PLANNING CONSULTATION RESPONSE

Application No	2025/0583
Proposal	Erection of detached two-storey dwelling with associated access and garage.
Address	Land adjacent St John the Evangelist Church, Carlton Road, Carlton, Barnsley.
Date of Consultation Reply	24/11/2025
Consultee	Katie Lawrence, Planning Ecologist

PROPOSED BOUNDARY TREATMENTS

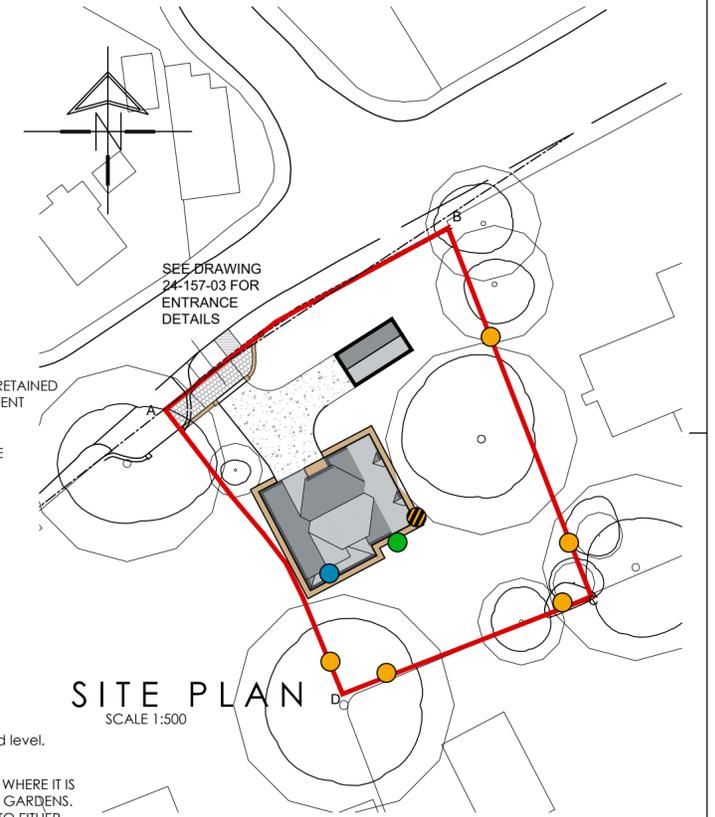
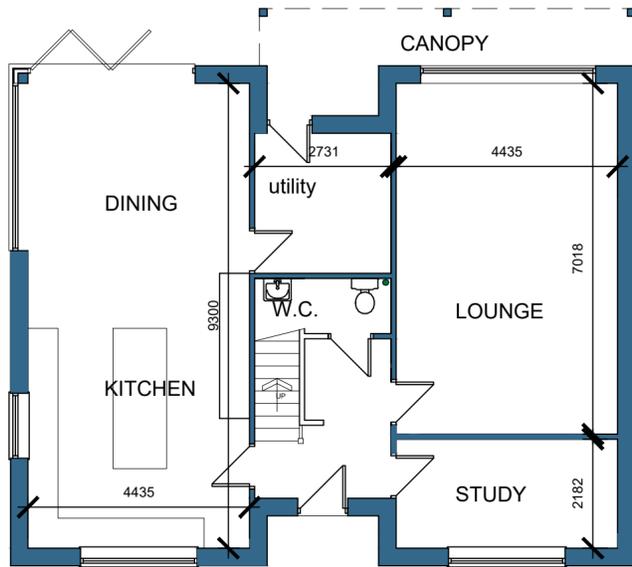
Thank you for sending through updated ecology information in support of the above application. The Preliminary Ecological Appraisal has been amended to include protective measures for retained features during construction, and the plans and elevations drawing (ref: 24-157 01, Rev. B) has been amended to include the swift brick in a different location, as requested. These proposals can be secured by way of a planning condition, as set out below.

The development shall be completed in line with the recommendations in the Preliminary Ecological Appraisal Report (ref no. 250160, January 2025) and Plans and Elevations drawing (ref: 24-157 01, Rev B) and the conditions of the planning permission. All the recommendations shall be implemented in full and thereafter permanently maintained for the stated purposes of biodiversity conservation.
